***MAJOR PROJECT ASSESSMENT:
Redevelopment of Hurstville Private Hospital
37 Gloucester Road, Hurstville NSW
MP 11_0042***

Director-General's
Environmental Assessment Report
Section 75I of the
Environmental Planning and Assessment Act 1979

April 2013

VIEW 5: ELEVATION AT CARPARK AND PROPOSED STORAGE DECK

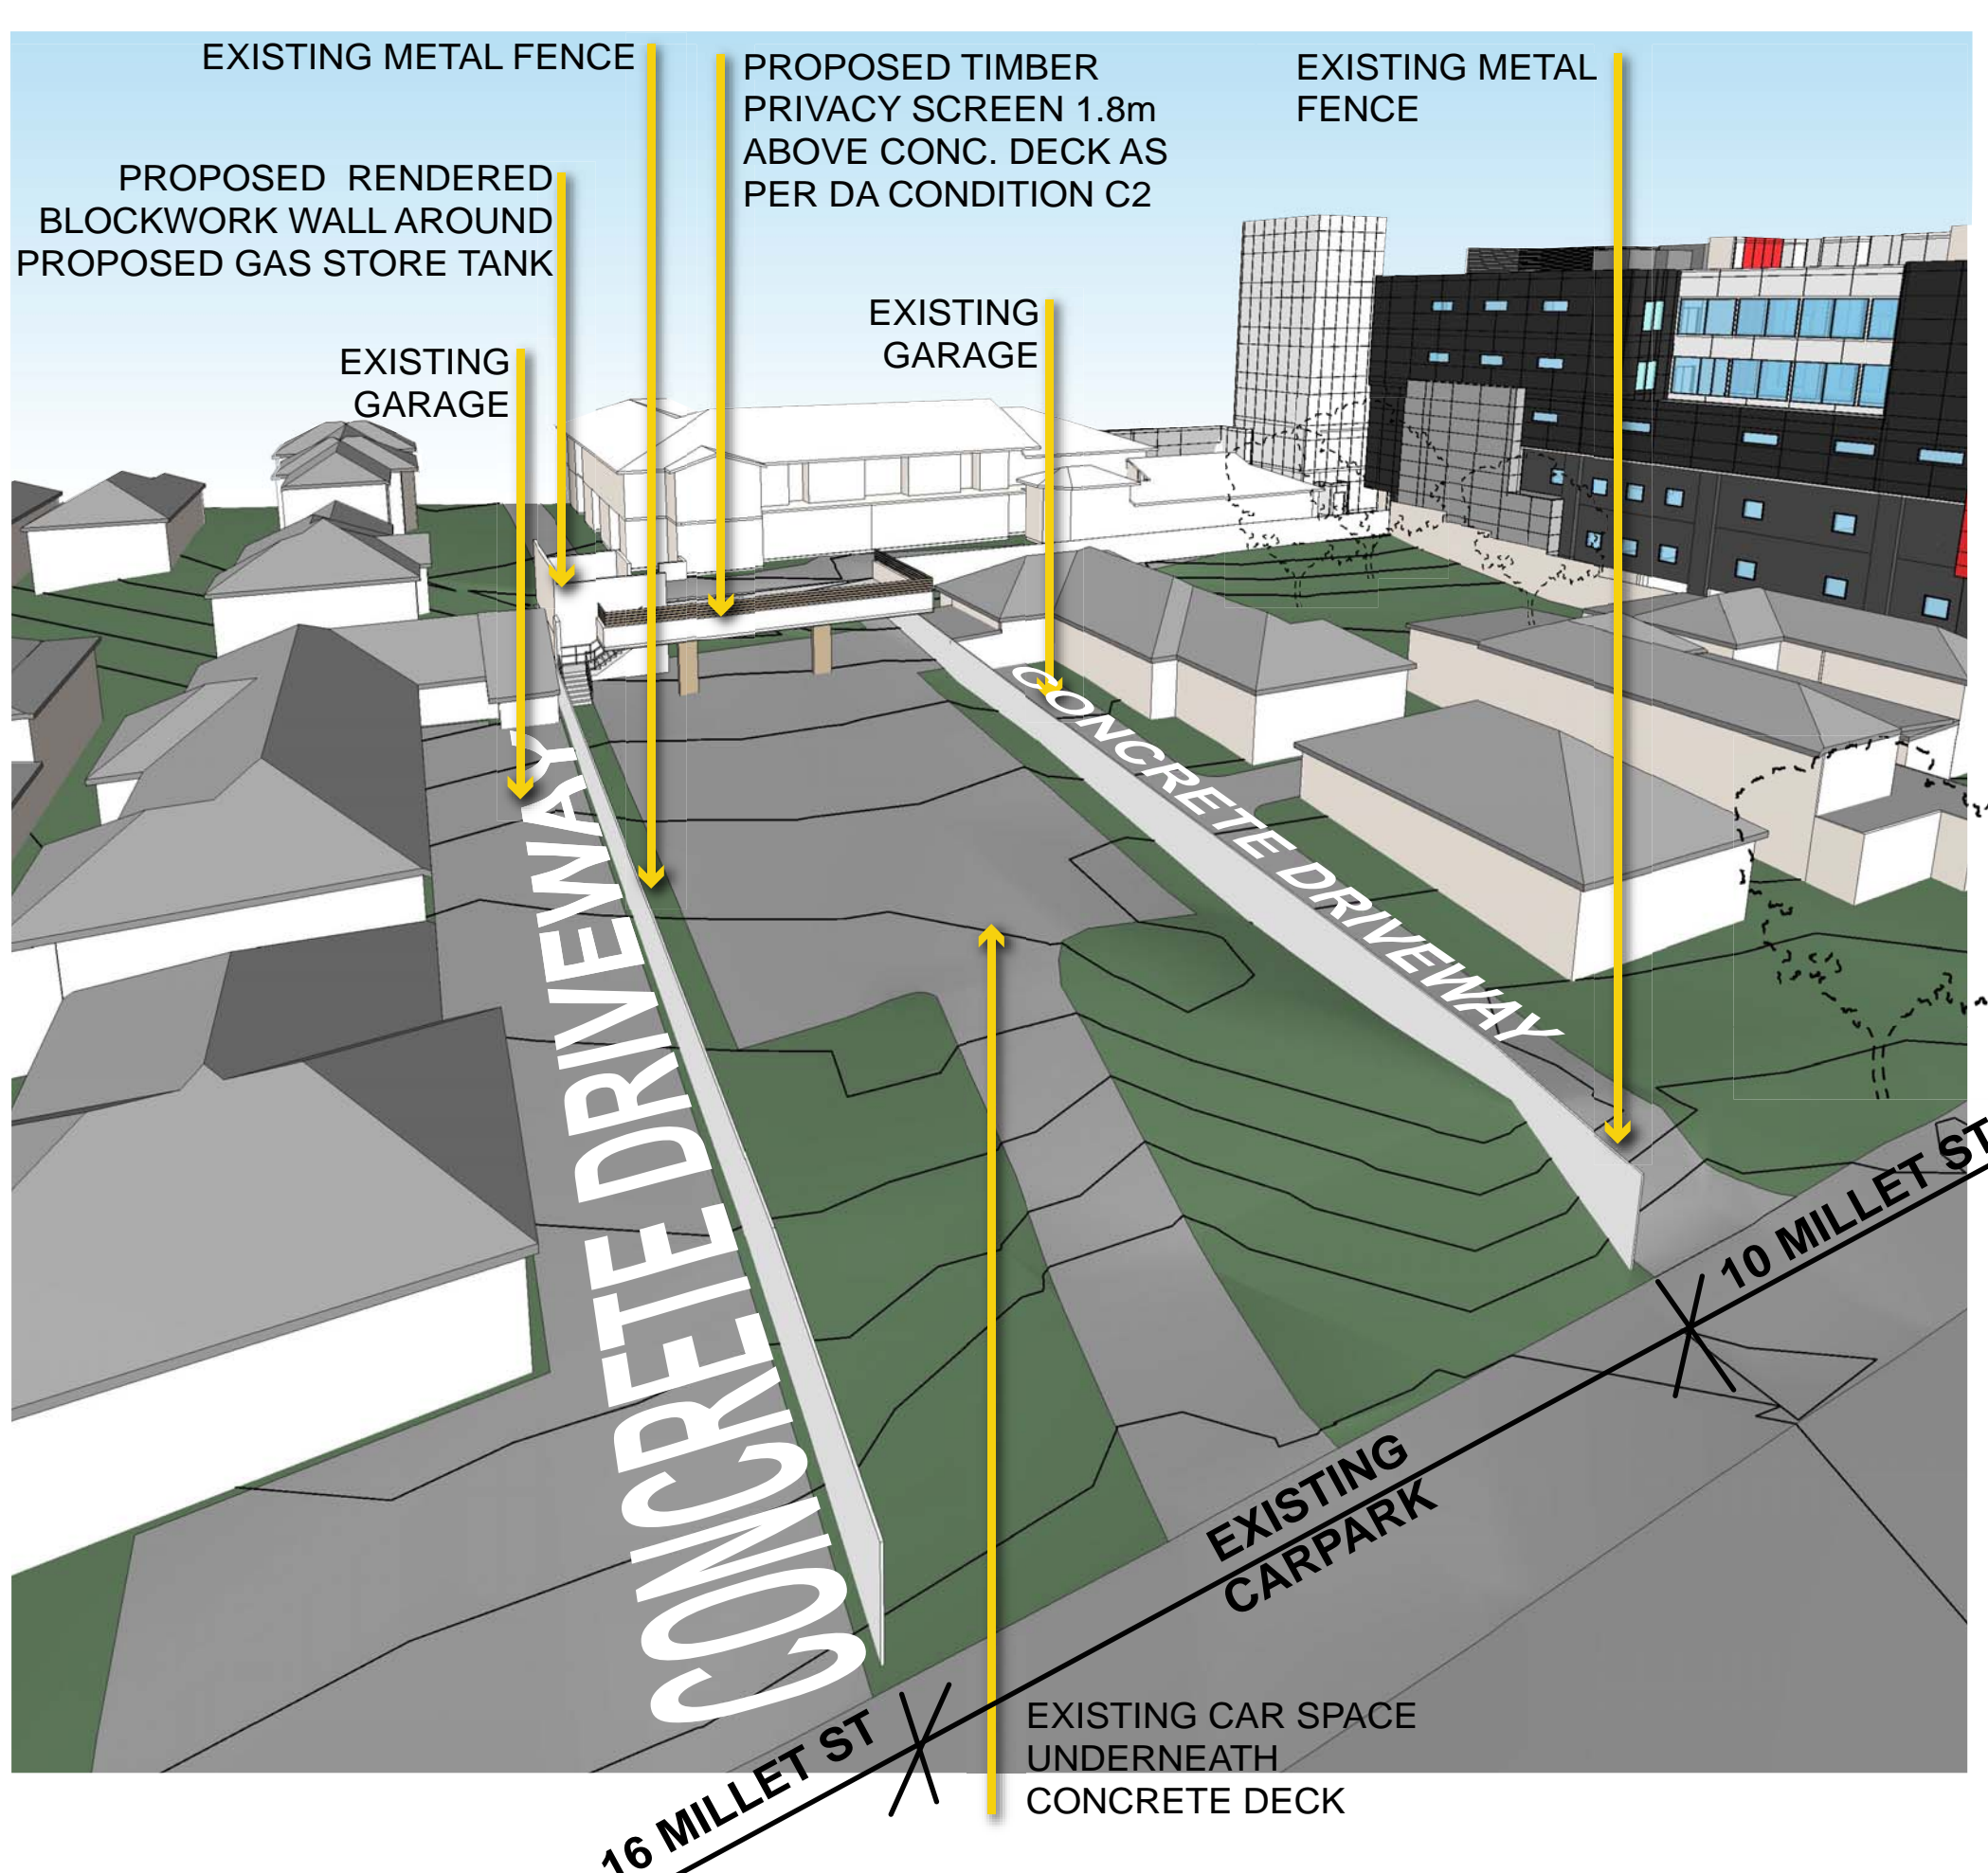
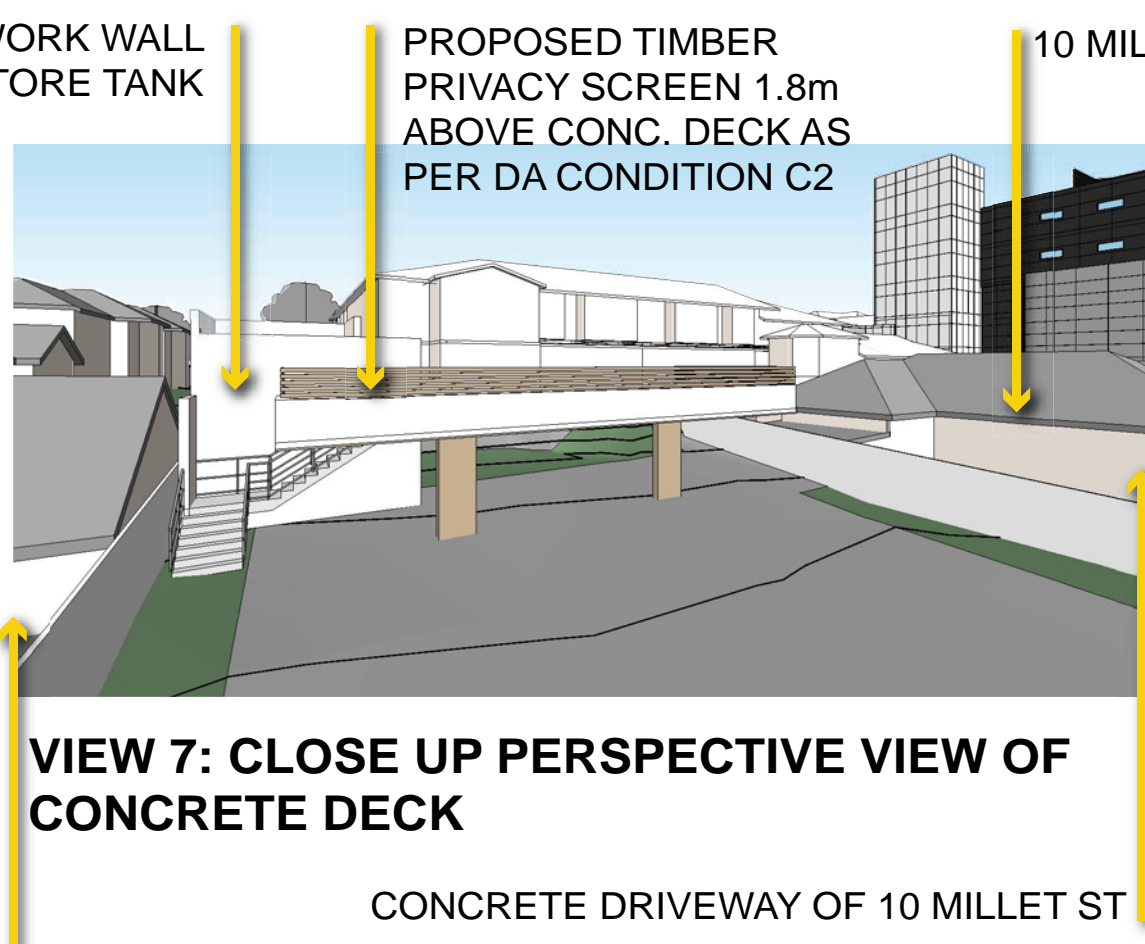
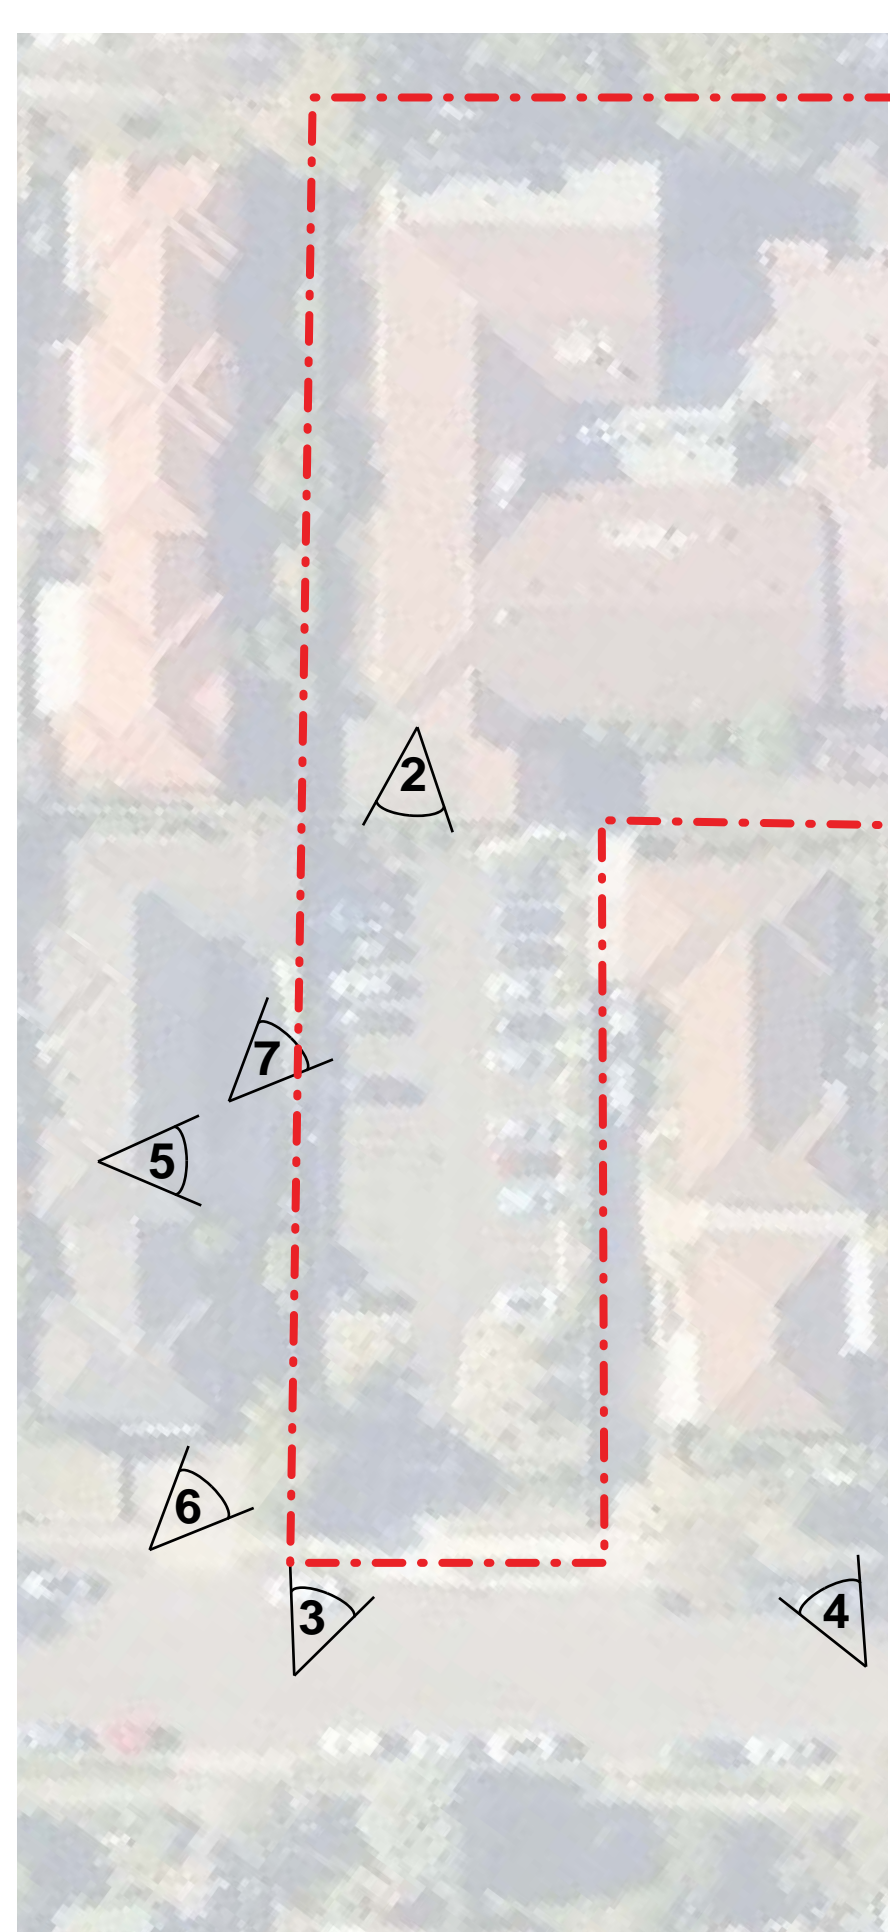
- The residential amenity issues arising from the proposed car park extension have been addressed by halving the extent of the proposed deck over 12 Millett Street. The Department has also required the provision of screening of the car park and frosted glazing to new windows overlooking 6 Millett Street (refer to **Section 5.2** of this report).

Key external amendments made to the proposal included a reduction in the size of the cantilevered car parking deck over 12 Millett Street and the relocation of the elevated walkway and lift tower in the new building.
